**SSD-10407 RESPONSE TO SUBMISSIONS (RTS)  
LIQUID WASTE TREATMENT PLANT AT 14-16 KIORA CRESCENT, YENNORA**

Our Ref: SYD19/01630/02  
DPIE Ref: SSD-10407

**SSD-10407L EXHIBITION OF ENVIRONMENTAL IMPACT STATEMENT (EIS)  
LIQUID WASTE TREATMENT PLANT  
14-16 KIORA CRESCENT, YENNORA**

Figure 2.1. Swept paths for heavy vehicles accessing the site at 14- 16 Kiora Crescent, Yennora. NSW Surveys PTY LTD, 8/11/19.

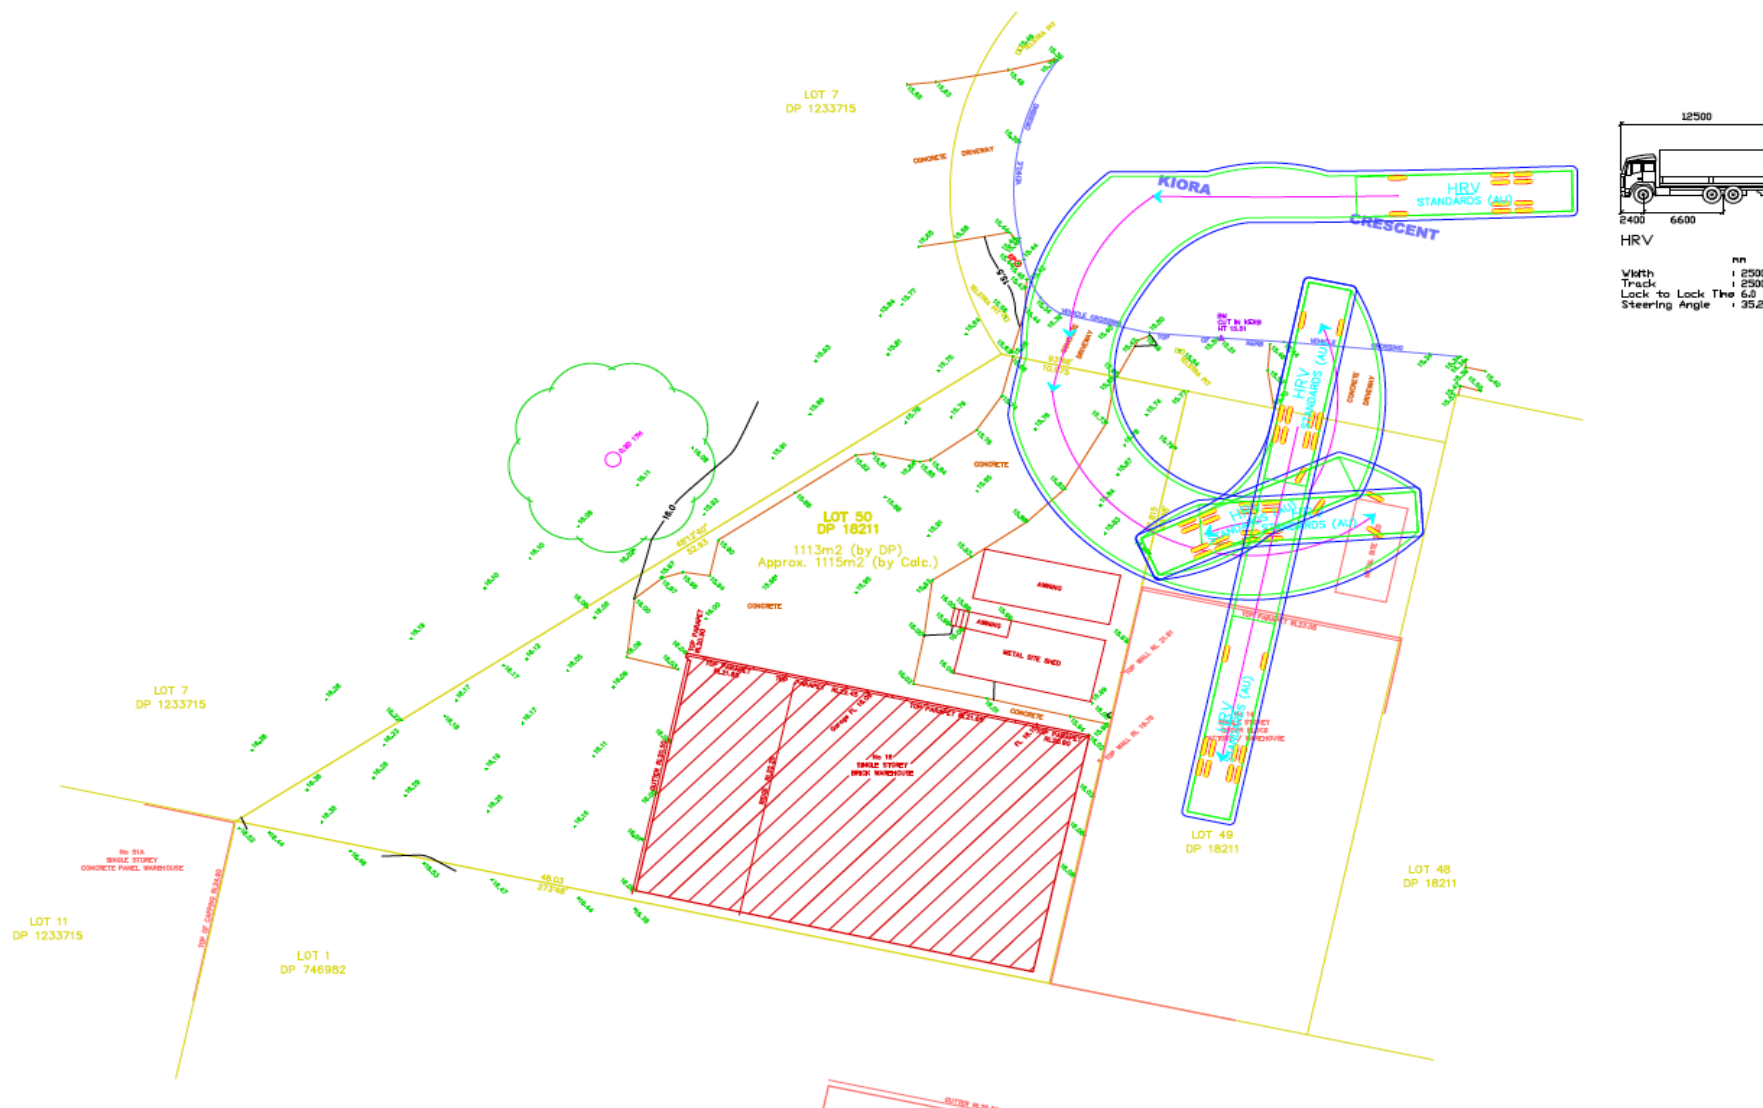
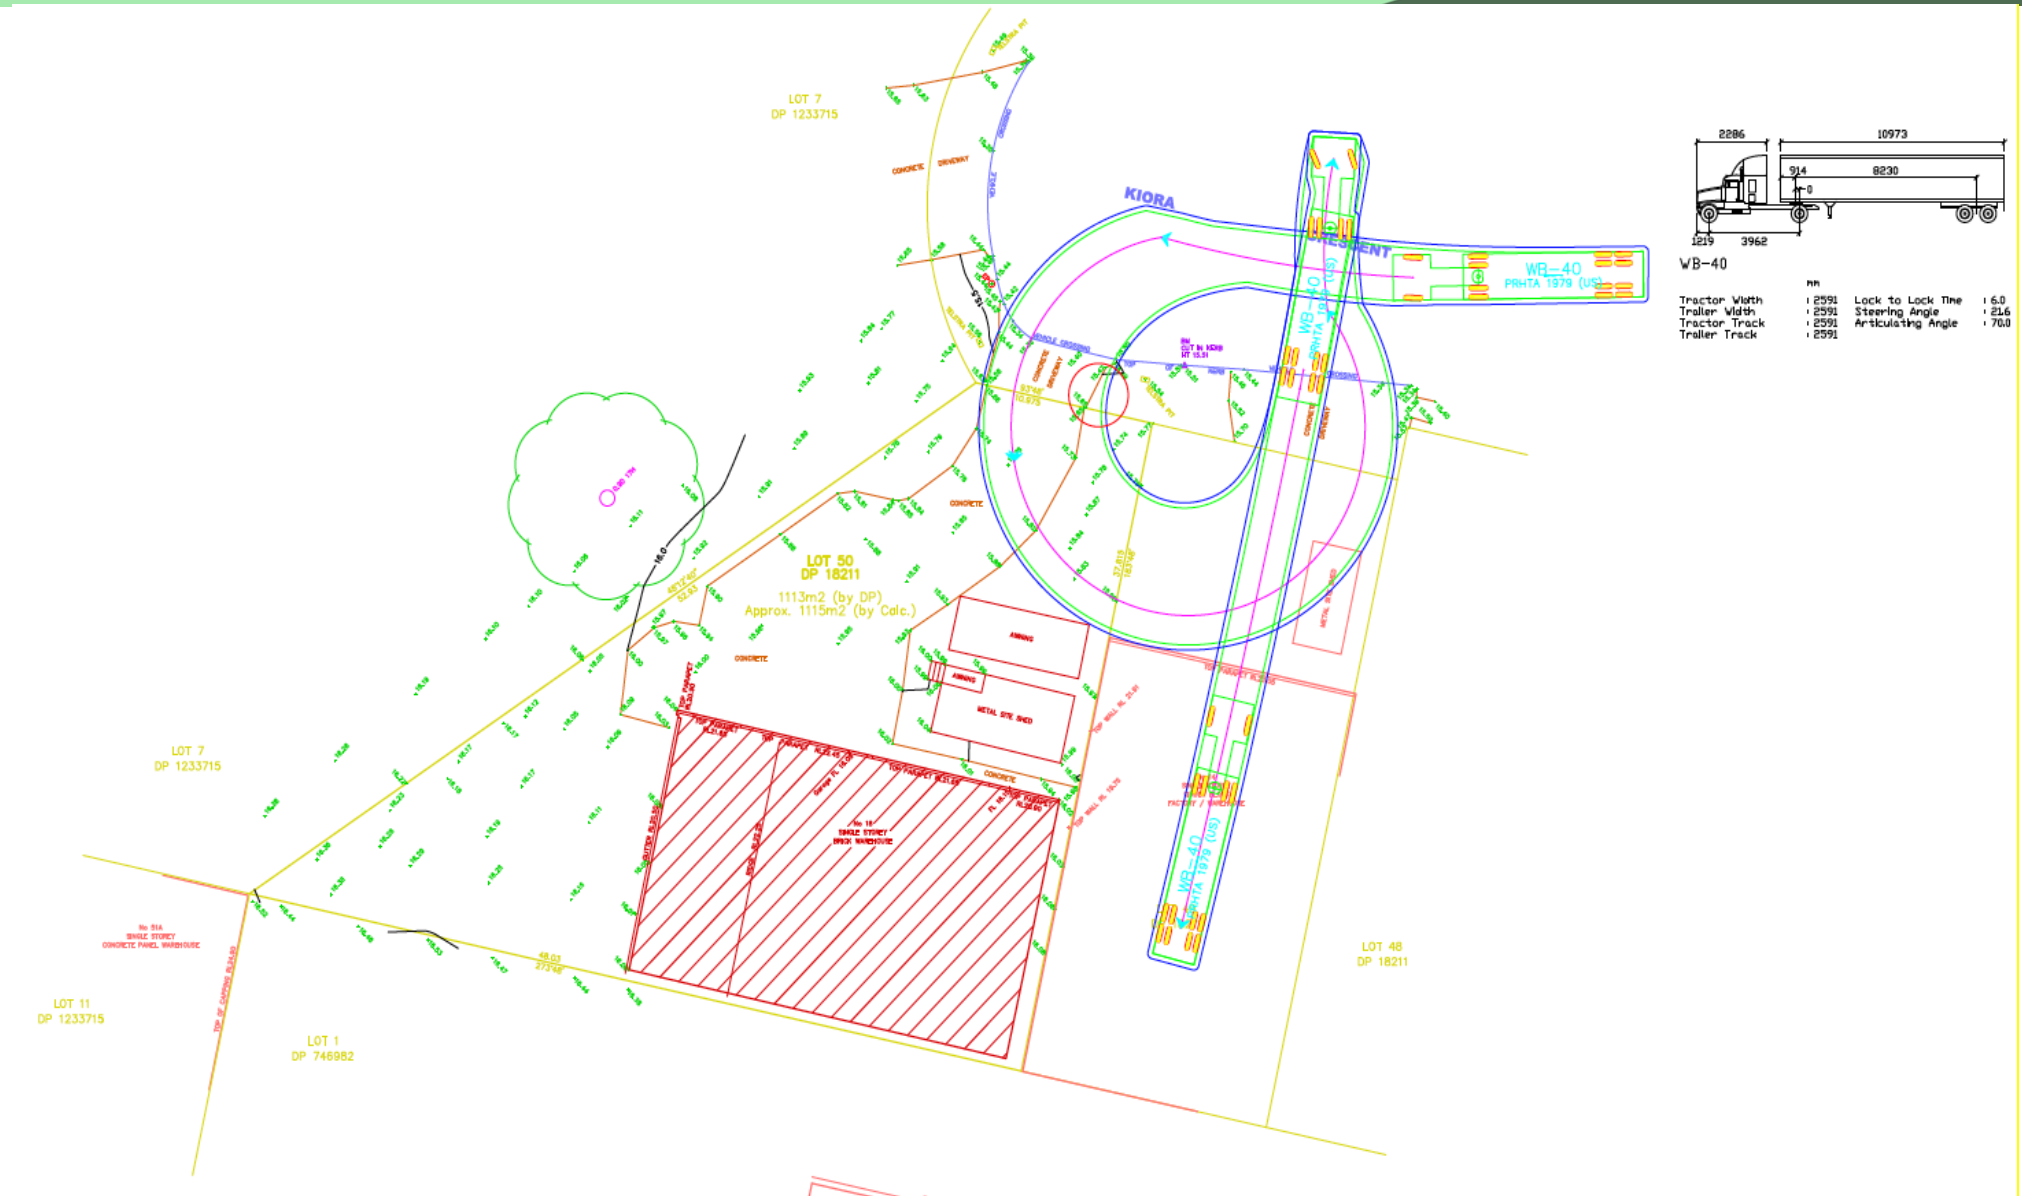
TfNSW notes that the swept path diagram (Appendix 8C) shows that the incoming trucks will be required to manoeuvre out of the 14 Kiara Crescent vehicle crossover, before reversing into the site.

As Kiara Crescent is under the care and control of Council, the proposed swept path design of the vehicle movements should be in accordance with Council's requirements. TfNSW requests that this addressed as part of the Response to Submissions (RtS).
